Comments for Planning Application 20/00934/FUL

Application Number: 20/00934/FUL

Address: Land To The Rear Of The George Inn 5 Sandford Road Littlemore Oxford Oxfordshire OX4 4PU

Proposal: Erection of 1 x 1 bed, 4 x 2 bed and 2 x 3 bed dwellings with associated off-street parking, private amenity, secure bicycle parking and recycling and refuse storage provisions.

Issue Date:	Scale:	Drawn:	Check:
22.07.2020	1:200 @ A1 @ A3	JR	JC
Job No	Disc.	Type	Number Revision
190277	A	ST	004 C

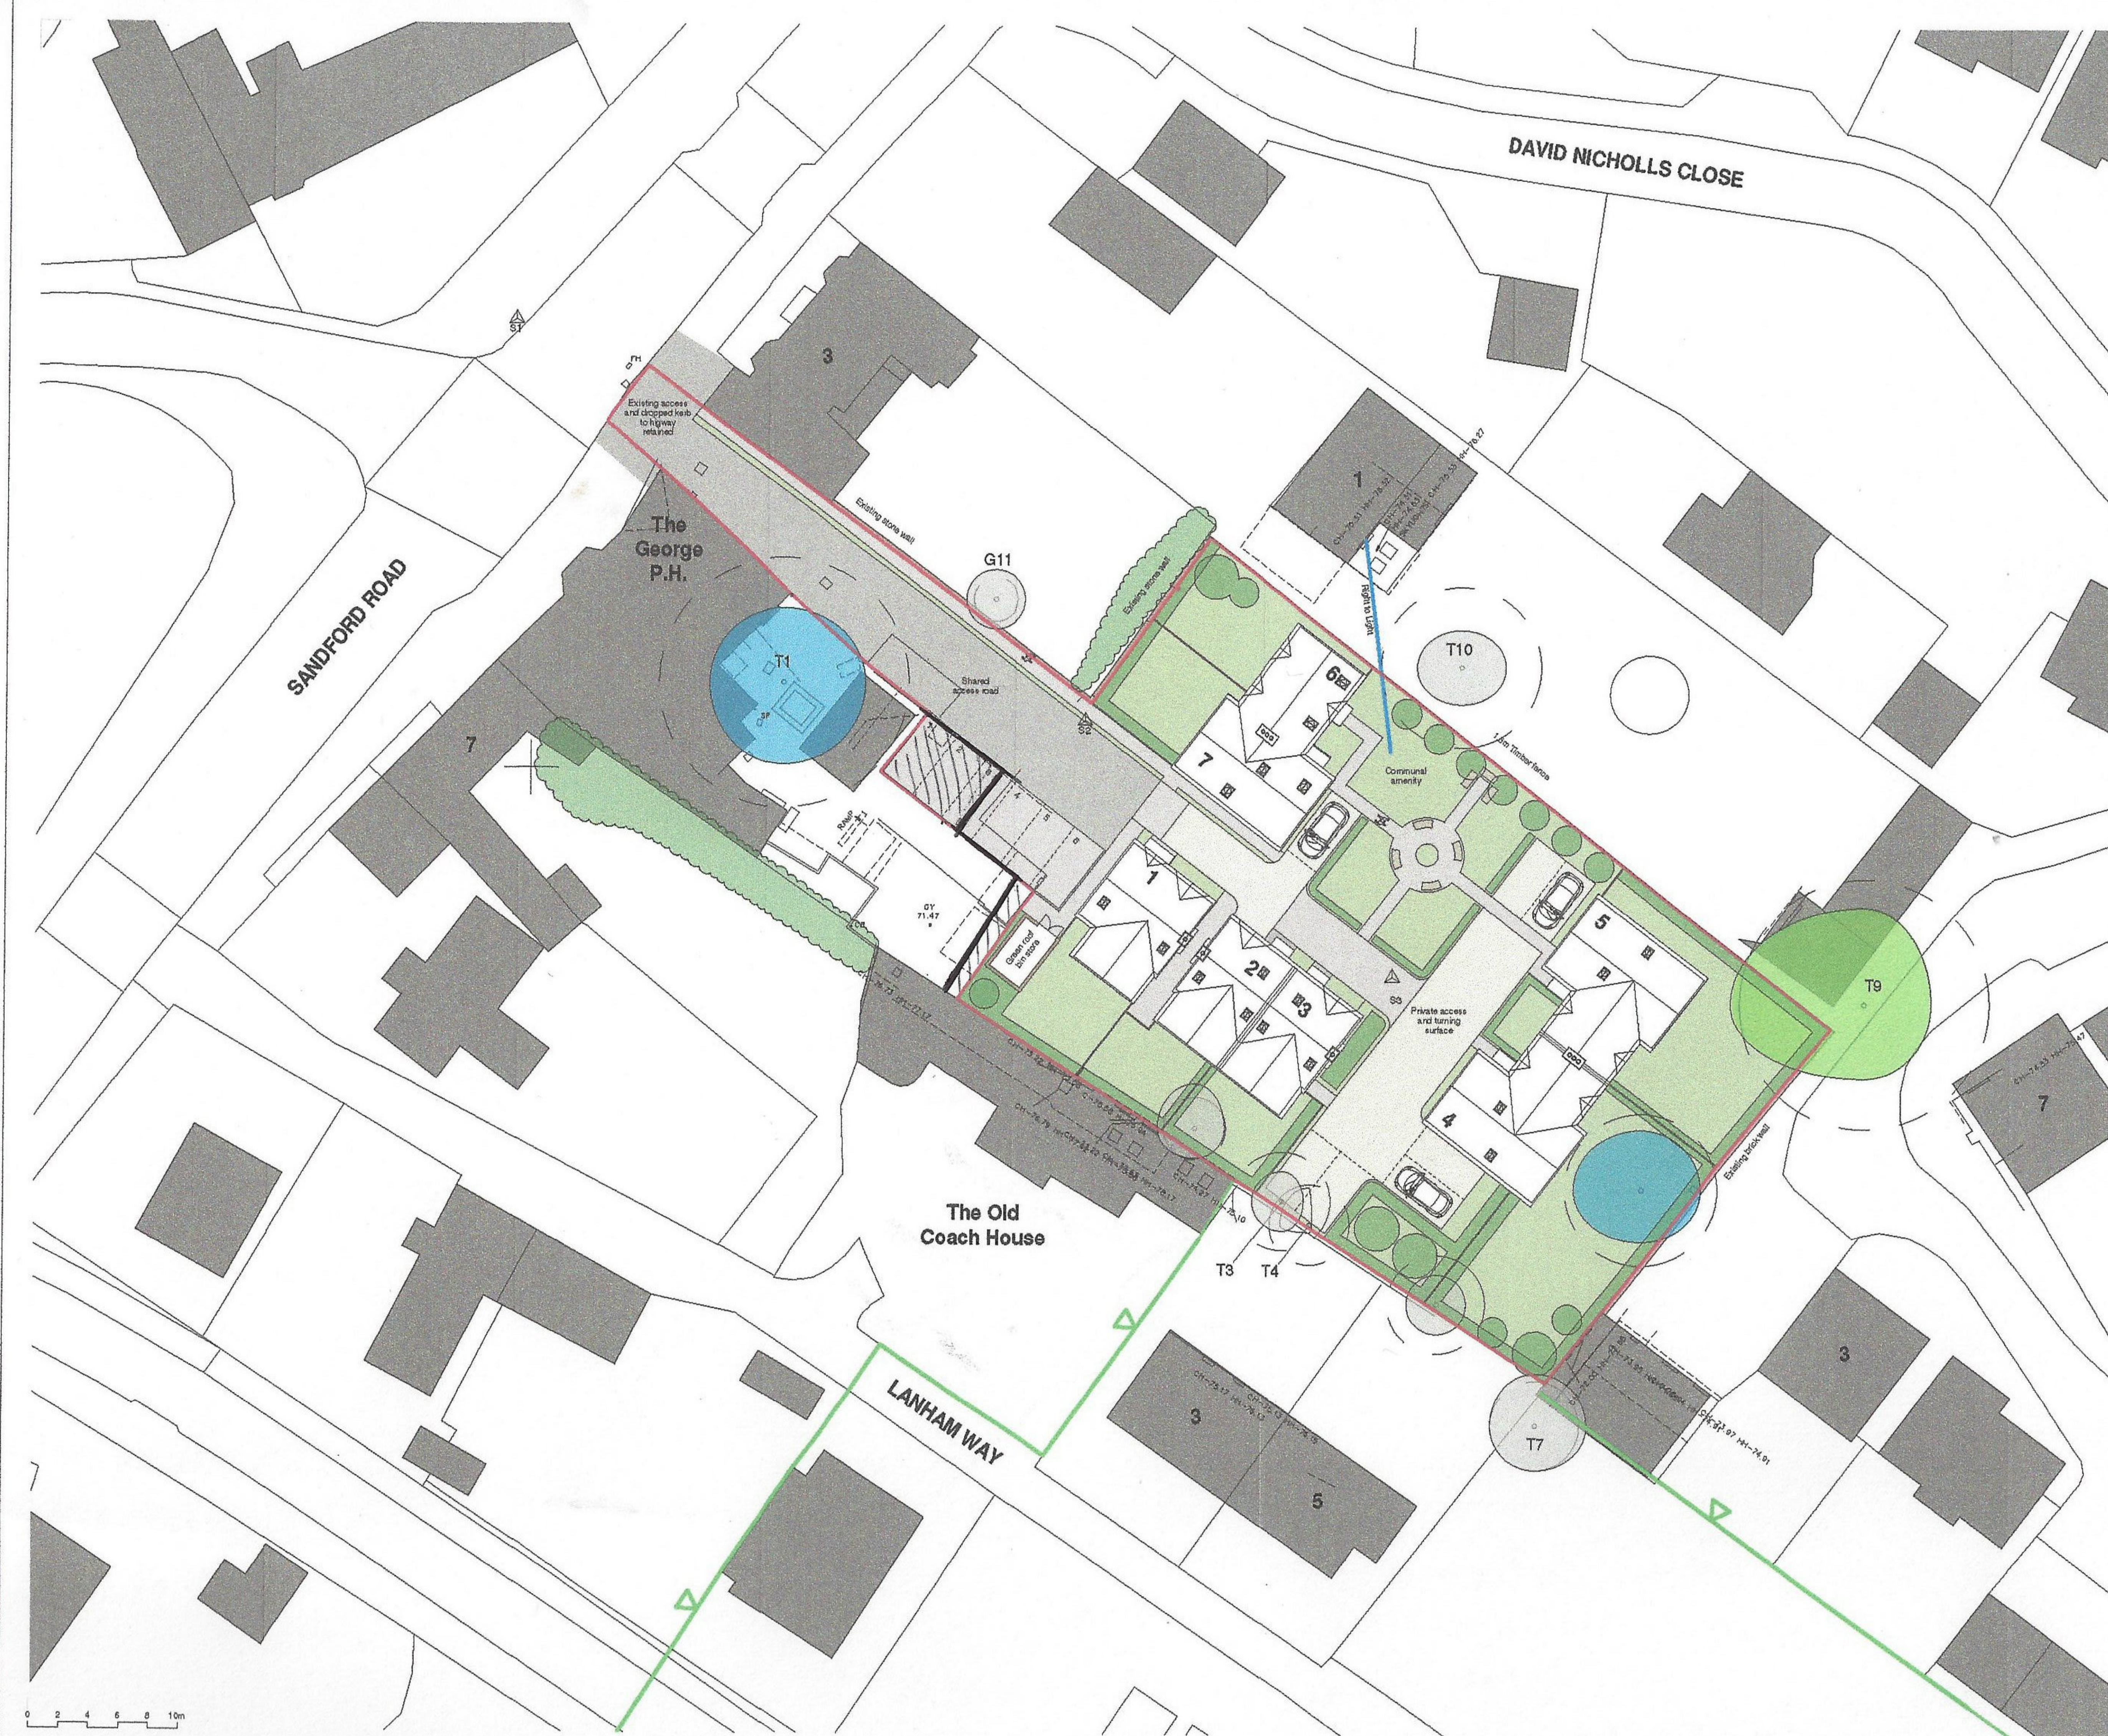
1, The access to the area for the houses to be built is not wide enough to take to cars side by side thus in and out traffic is severely restricted, and half the vehicle leaving the area is on the path, obstructing pedestrians and the nearby zebra crossing.

To overcome this problem the applicant has shown on his plans to 'reduce the size' of the pub to make the drive wider which has to be a totally unacceptable situation, if it is not suitable then there is no argument for the dwellings to be built. In addition to this argument as the drive stands a fire engine would not be able to go up the drive in the need of an emergency in the proposed dwellings
